Re: Cleanaway ResourceCo RRF Modification 4 - 24/7 operations (SSD-7256-Mod-4)
Request for Additional Information

Appendix A: Wilkinson Murray response to Issues Raised by EPA in relation to Acoustic Report

Re: ResourceCo, Frank Street - Noise Clarifications

Figure 2-2 ResourceCo Facility Layout

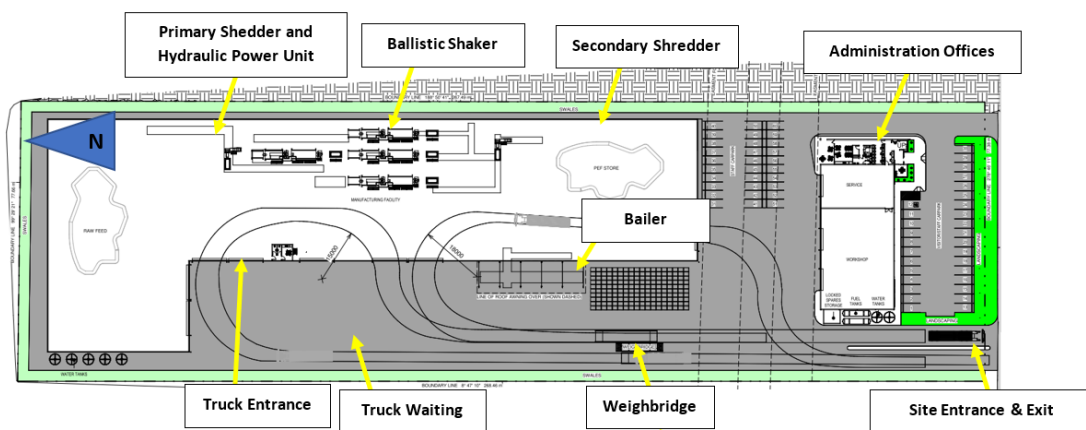
- The Report references monitoring that was conducted at the facade openings. Further clarification is required specifying exactly where monitoring was undertaken, including the location displayed on a map. If the monitoring was conducted outside the building, confirmation is required whether the door into the building was open or closed.

Refer plan from report with monitoring locations highlighted. F is the facade location described as at one of the openings. W is for western boundary and E for eastern boundary near the entrance. Doors on the west were in their normal position some of which were open during the measurements.
